Your Ref: OWPC19542
Our Ref: LU/189/18/PDH 05-07-2018
Please ask for:
Zac Denton

Notification under extended development rights for new proposed single storey rear extension extending 5.96m from the original rear wall of the dwelling house, 3m high with an eaves height of 2.55m

48 Northway Road Littlehampton

48 NORTHWAY ROAD, LITTLEHAMPTON
Existing details 01

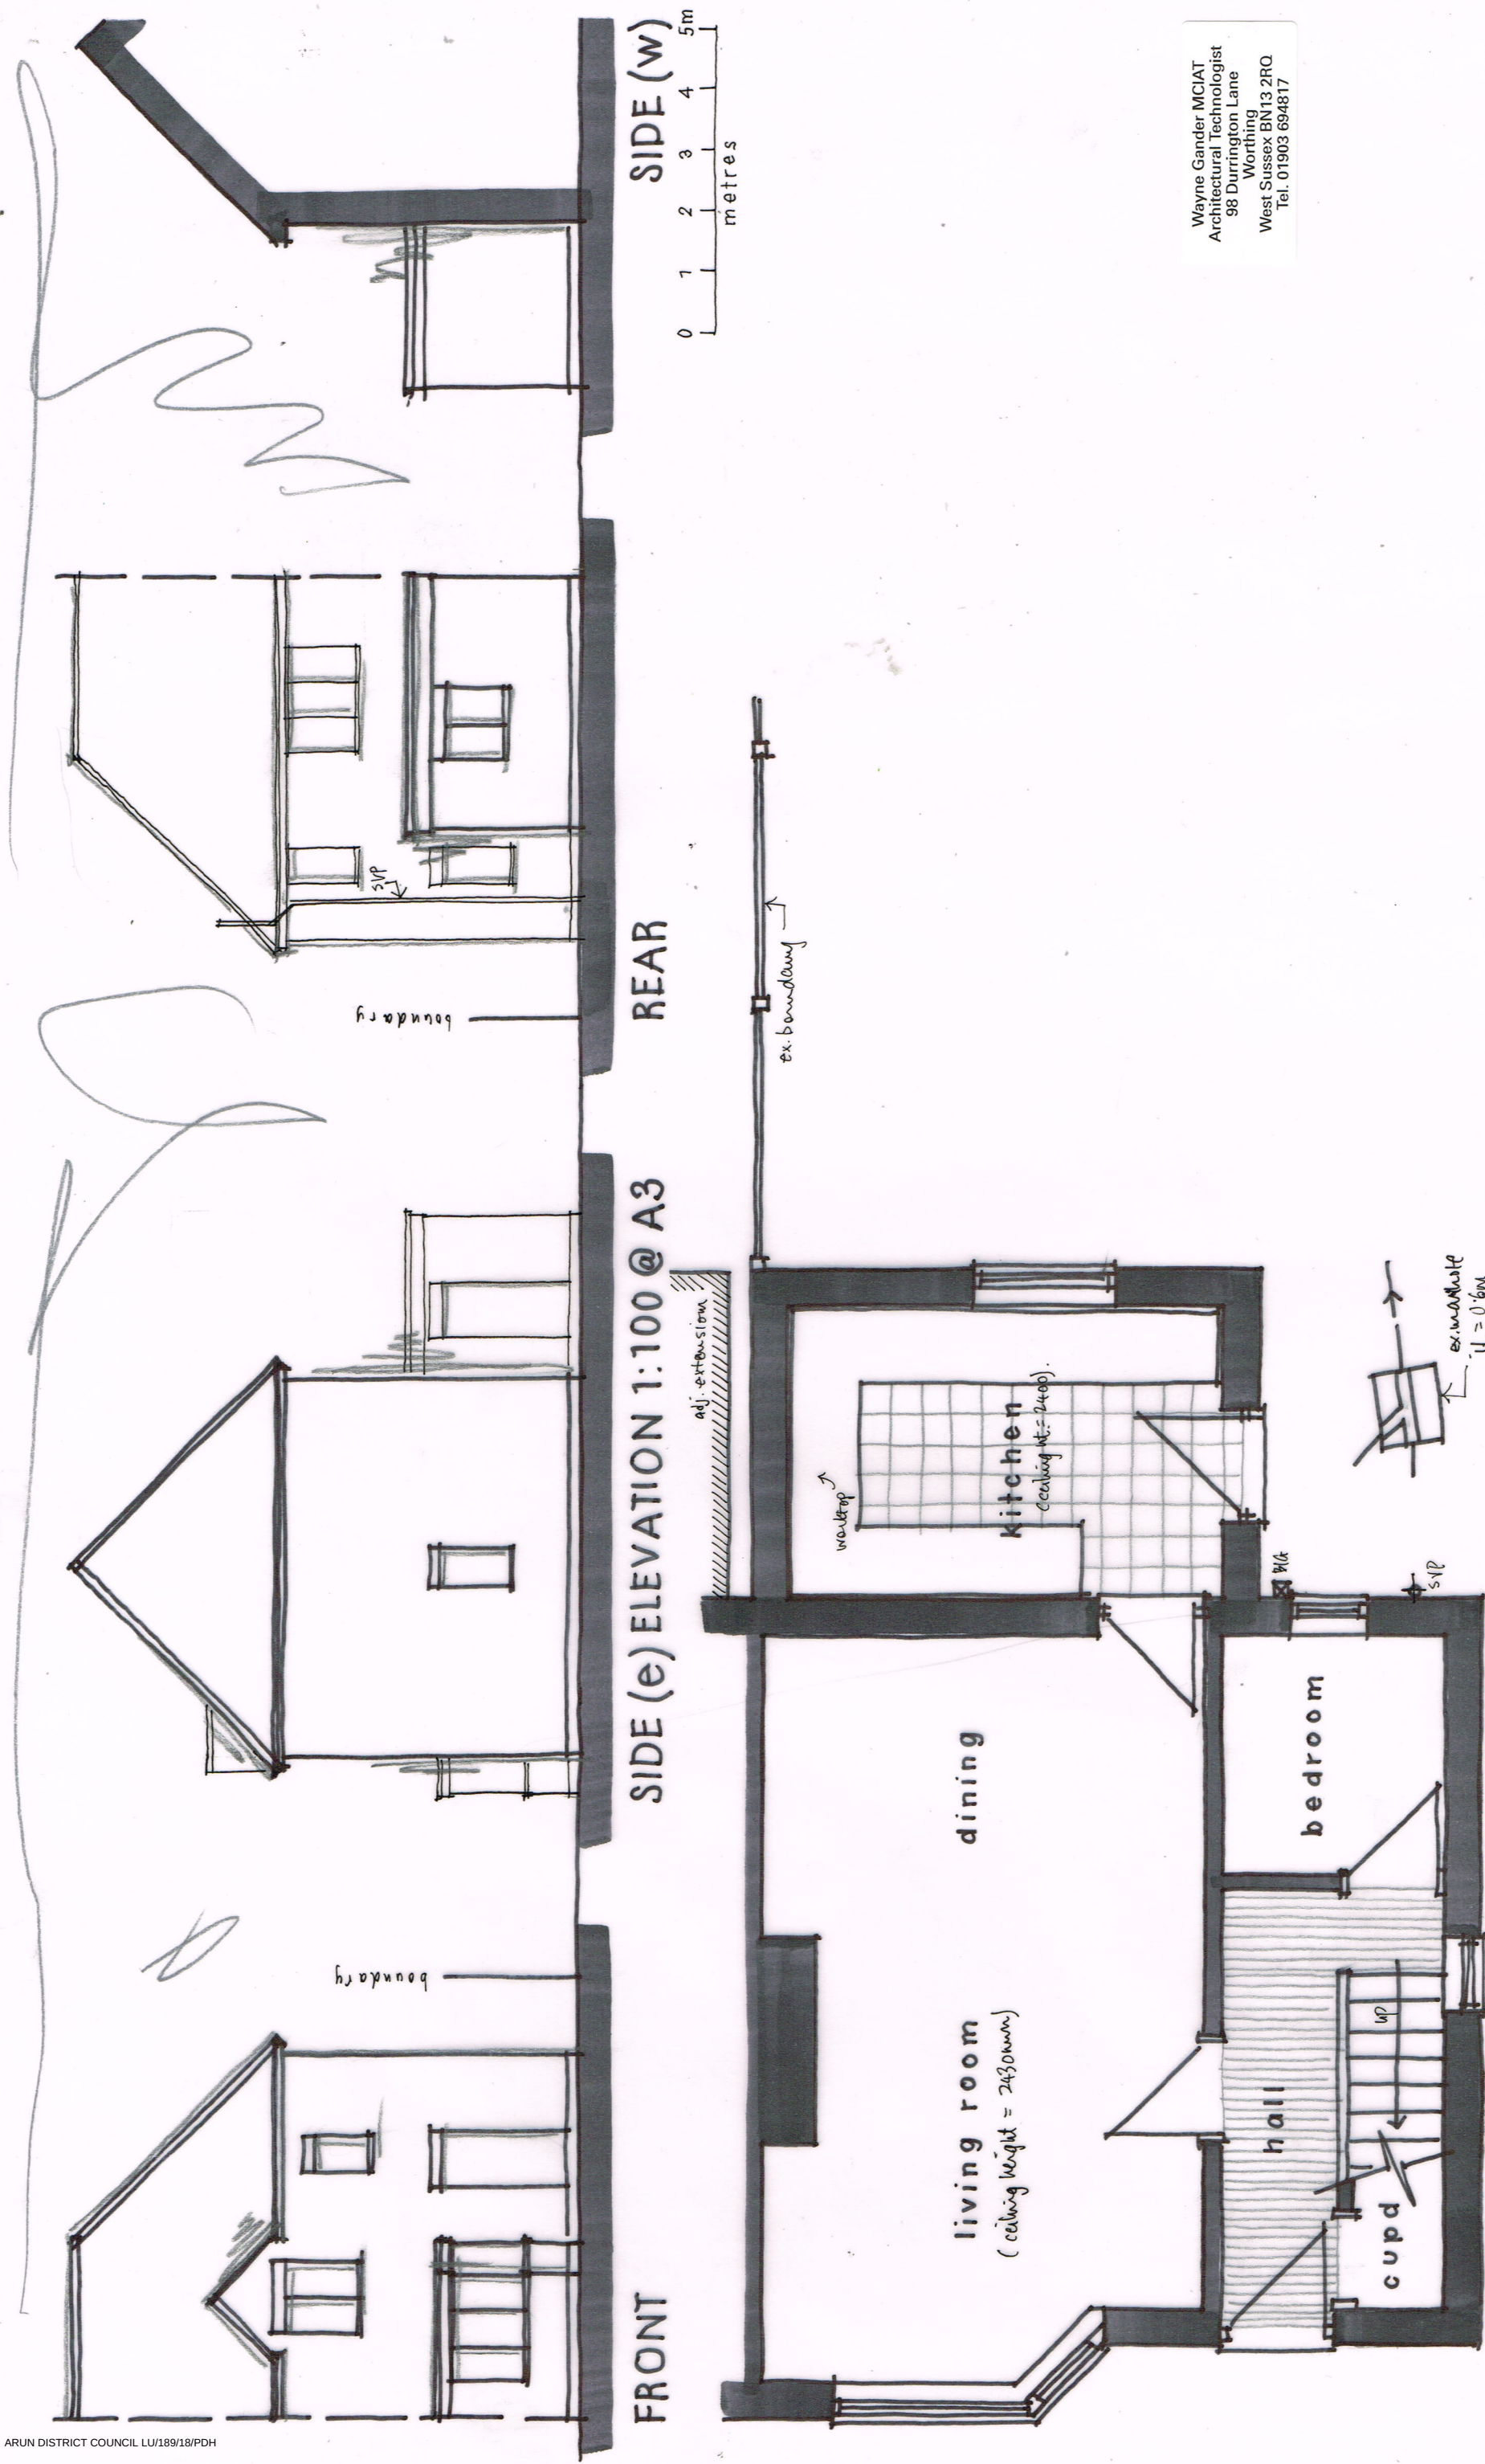
My concerns relate to Mr Jones existing extension and intentions to build directly onto their existing extension wall, currently overlapping into my garden. I have had extensive discussions with Land Registry who are unable to give exact boundary line; they said boundary's change over time. When I moved in 31 years ago, existing extensions and the fence line was as it currently is.

1. The plans submitted as part of the application, do not make specific reference to the correct and defined boundary that exists between both properties. I am of the opinion that this has been done to intentionally miss-lead. If the boundary as shown is correct, then the proposed extension can only be constructed by way of entering my property (e.g. concrete foundation bearing, scaffolding, guttering, roofing etc.). Even if the correct line of the boundary is such that it runs midway between the properties, there is still insufficient distance to allow construction without the need to enter my property. This would be the subject of a Party Wall agreement for which the Applicant has dismissed to provide and/or enter into. Further, if the brickwork, which is shown on the boundary line ever, required maintenance, this too could only be accessed by way of entering on my property. For the avoidance of doubt, I consider any such entrance to my property as Trespass, and will contact the relevant authorities should the need arise. Therefore, if the Application was to be passed (which it should not as currently proposed), it should only be done so with the strict condition that the external walls are constructed at least 1 metre away from the

boundary line between both properties.
